## **\*PRE-HEARING STAFF ANALYSIS\***

### **Rezoning Petition No. 2008 - 056**

**Petitioner:** Hathaway Development Company

**Request:** R-4, single family to R-17MF(CD), multi-family conditional district

DATE: MAY 19, 2008  
 DRAWN BY: M. HUGH  
 CHECKED BY: M. HUGH  
 Q.C. BY: AP  
 SCALE: 1" = 60'-0"  
 PROJECT #: 018501  
 SHEET #: C.1.0

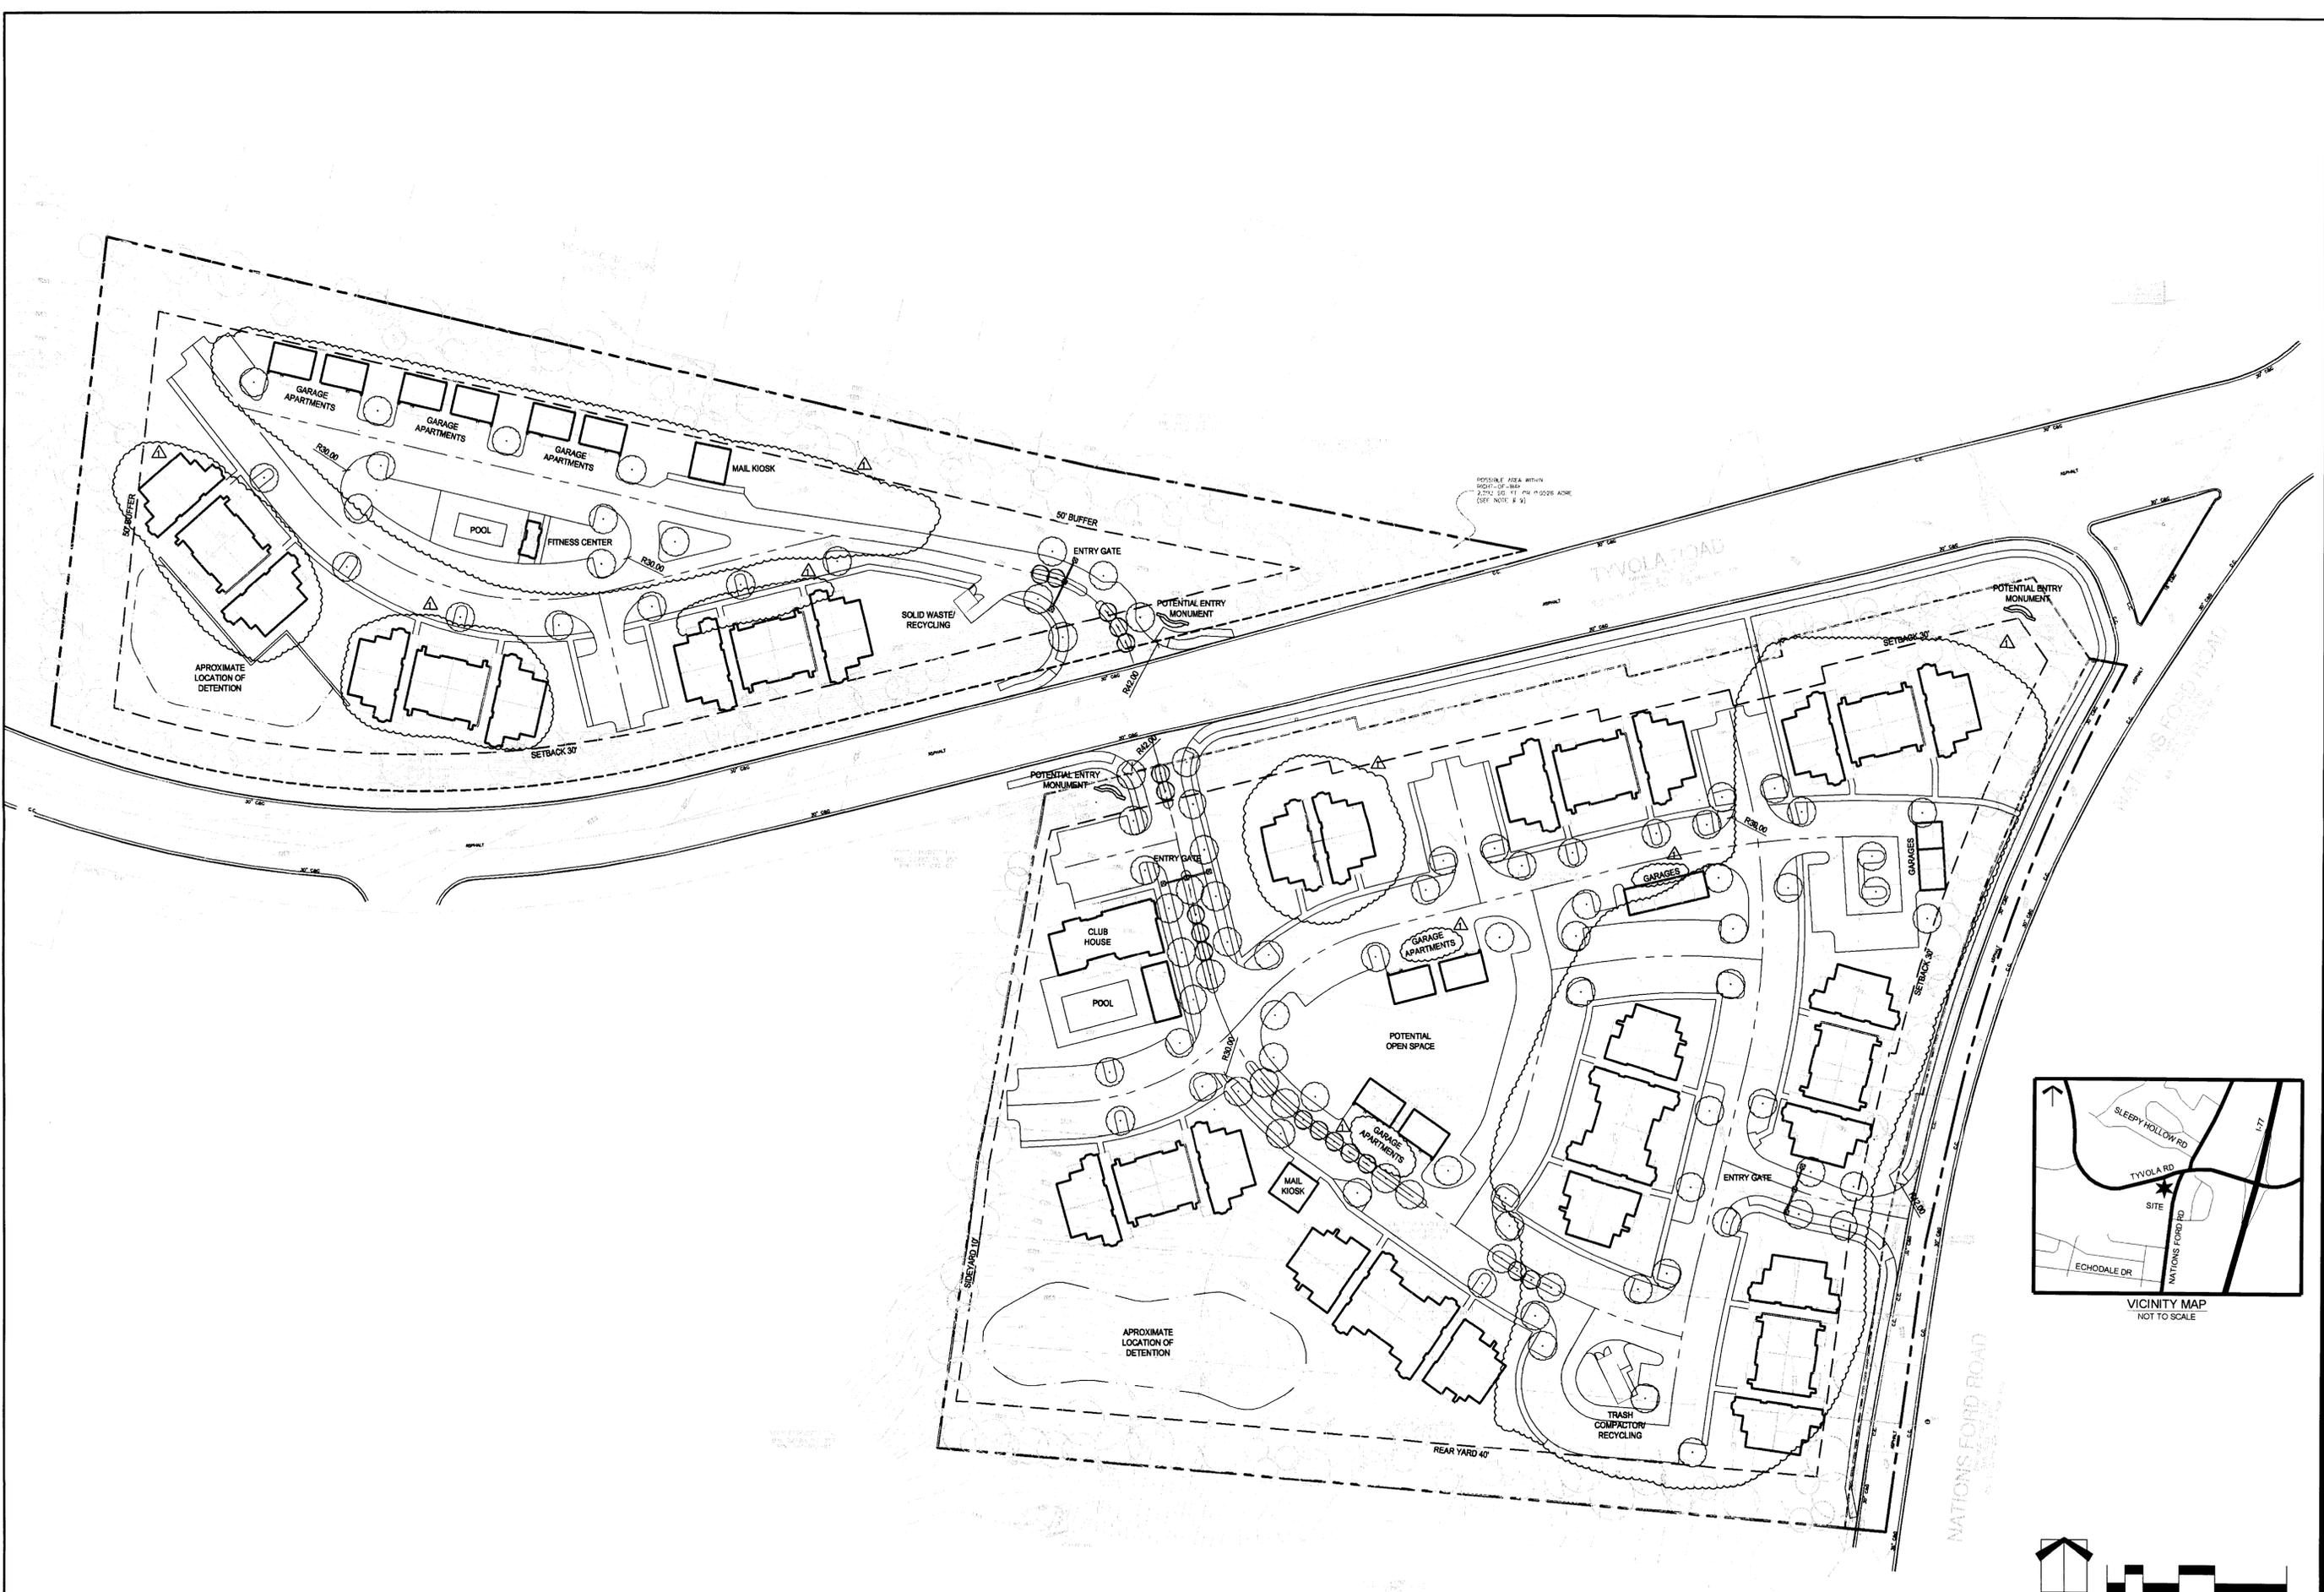
- The petitioner should label the buildings along the northern property line on the property on the north side of West Tyvola Road as garage apartments.

- The petitioner should provide an additional 5-foot wide sidewalk connection from the interior sidewalk on the west side of the property located on the north side of West Tyvola Road to the sidewalk along West Tyvola Road.

- The petitioner should show all building entrances at least 15 feet from private streets or surface parking.
- The petitioner needs to correct the parking requirements to 306 spaces on the parcel on the south side of West Tyvola Road to meet minimum ordinance standards.

- The three buildings on the northeast corner of the property located on the south side of West Tyvola Road do not meet the maximum 400-foot separation (as the vehicle travels) from a public or private street (as defined by the ordinance).

- The garages with apartments above on the property on the south side of West Tyvola Road must be located a minimum of 20 feet from the back of the sidewalks.

- The petitioner should provide an additional 5-foot wide sidewalk connection from the interior sidewalk on the northeast portion of the property on the south side of West Tyvola Road to the sidewalk along Nations Ford Road.

- The petitioner should indicate, on the site plan, that they will construct 6-foot wide sidewalks with 8-foot wide planting strips along Nations Ford Road and West Tyvola Road.

- The petitioner should correct the lighting note to indicate lighting fixtures will be shielded with full cut-off.

- The petitioner should show a required 50-foot wide Class “C” buffer and rearyard on the northern and western property lines of the property on the north side of West Tyvola Road.
- The petitioner should show tree save areas and include a tree survey for areas within setbacks.
- The petitioner needs to correct the acreage for both parcels on sheet C.1.0 to reflect the total 19.1 acres.
- The petitioner should correct the note regarding installation of a fence on the perimeter of the site to indicate any fence installed within a buffer will be located on the interior half of the buffer.
- The petition number should be indicated on the site plan.
- The petitioner should address outstanding CDOT comments.
- The petitioner should address all outstanding Mecklenburg County Land Use and Environmental Services Agency comments.
